DECISION DELEGATED TO DEVELOPMENT MANAGER

Application No: H19-0965-20 **Applicant:** Mr & Mrs C Fear
Proposal: Two Storey Extension to House
Location: Hollytree Farm Hall Gate Road Sutton St Edmund
Terminal Date: 23rd December 2020

SECTION B - B

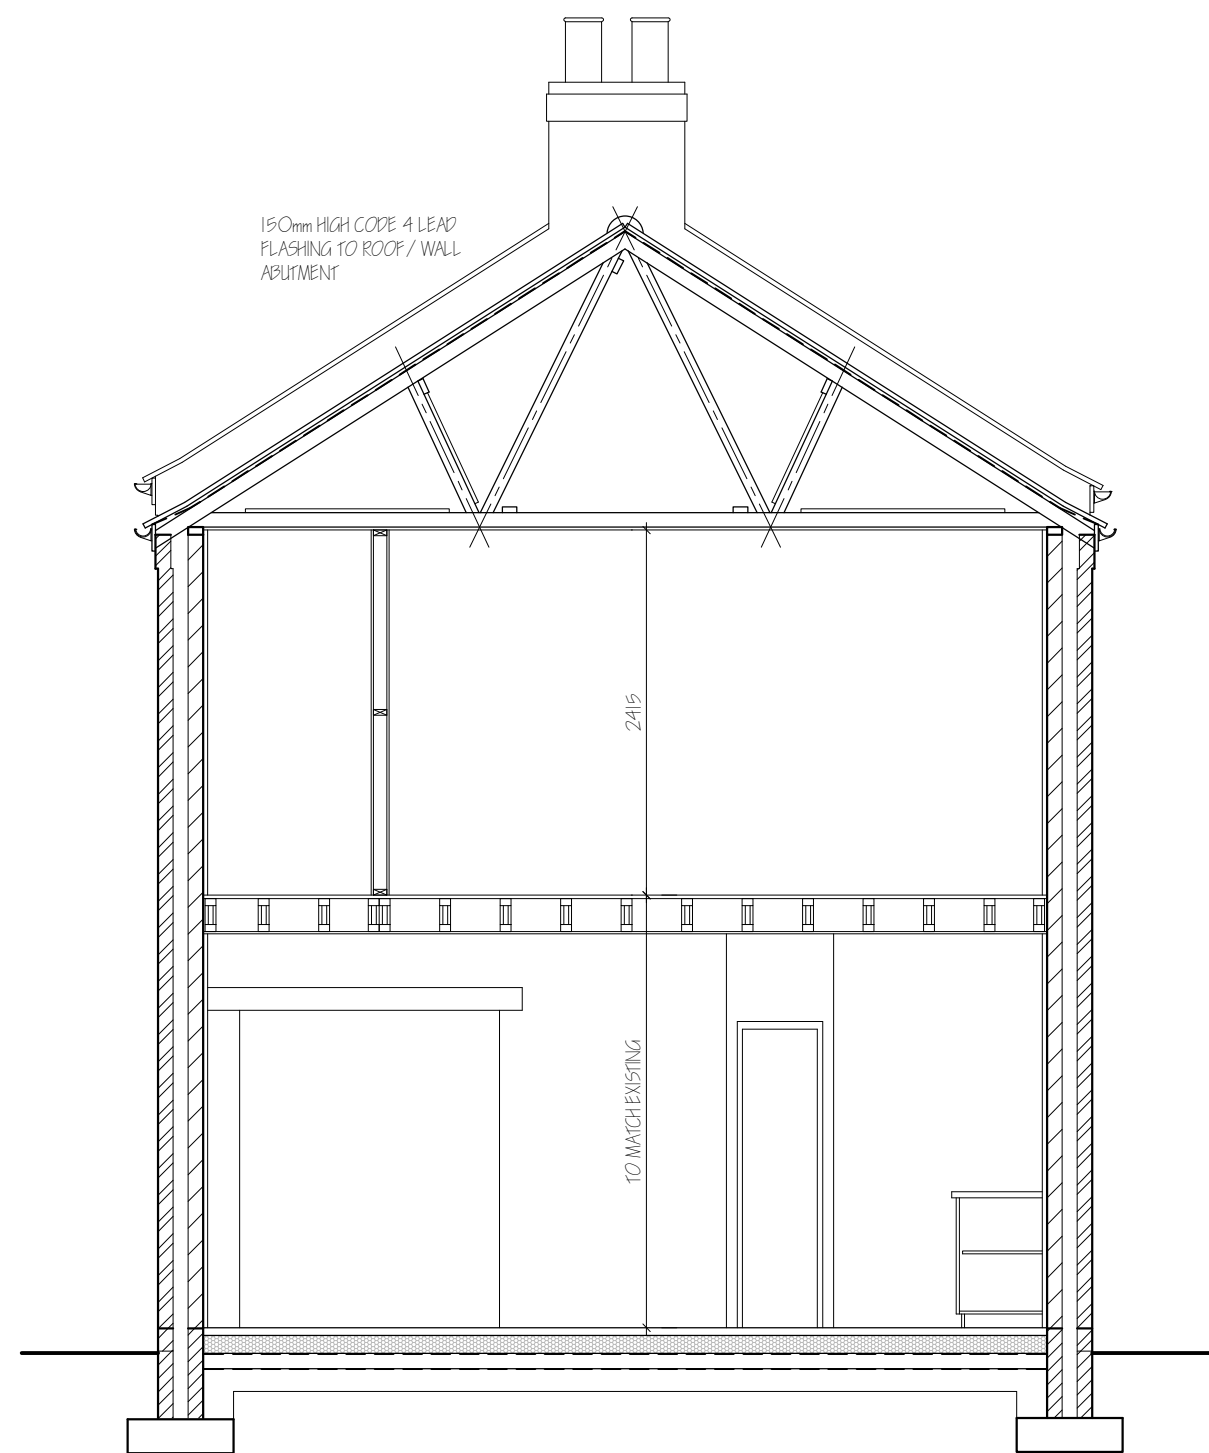
The proposed two-storey extension will protrude 4.95 metres from the western side wall. The depth will be as much as the gable wall. Its apex height will be 7.50 metres which is 20 centimetres below the ridgeline of the house. The porch at the rear elevation will be marginally widened. Having also regard to the dimensions of the house, it is concluded that the proposals will be subservient to the host property in terms of scale, mass and bulk.

A gable pitched roof will be formed tantamount to the existing roof of the dwellinghouse. Stone lintels and sills as well as brick detailing off the fascia will be replicated in the extension matching

the existing features of the house fabric. All elevations of the proposed extension will be facing brickwork. Render will be applied on the southern (front) and eastern (side) elevation of the original house. Despite the new material of render, the proposed design and layout of the proposals will be still congruous with the original fabric of the house.

Internally, the proposed development will gain further floorspace for a new kitchen on the ground floor level and one ensuite master bedroom on the first-floor level. The existing kitchen will be replaced for a study room. The purpose of the development will meet the householder living needs and in keeping with the residential use of the building.

The barn to the south of the dwellinghouse is awaiting permission for conversion into single dwelling. Should permission be granted, no significant overlooking effect will occur between the front windows of the extension and those in the new dwelling. The separation distances will be in the region of 15 metres and there will be no first-floor windows other than roof lights for non-habitable loft space.

The additional bedroom proposed would increase the total number of bedrooms from 3 to 4. Three spaces for dwellings with 4 or more bedrooms should be provided within the curtilage. The drive area is visibly spacious to accommodate three cars.
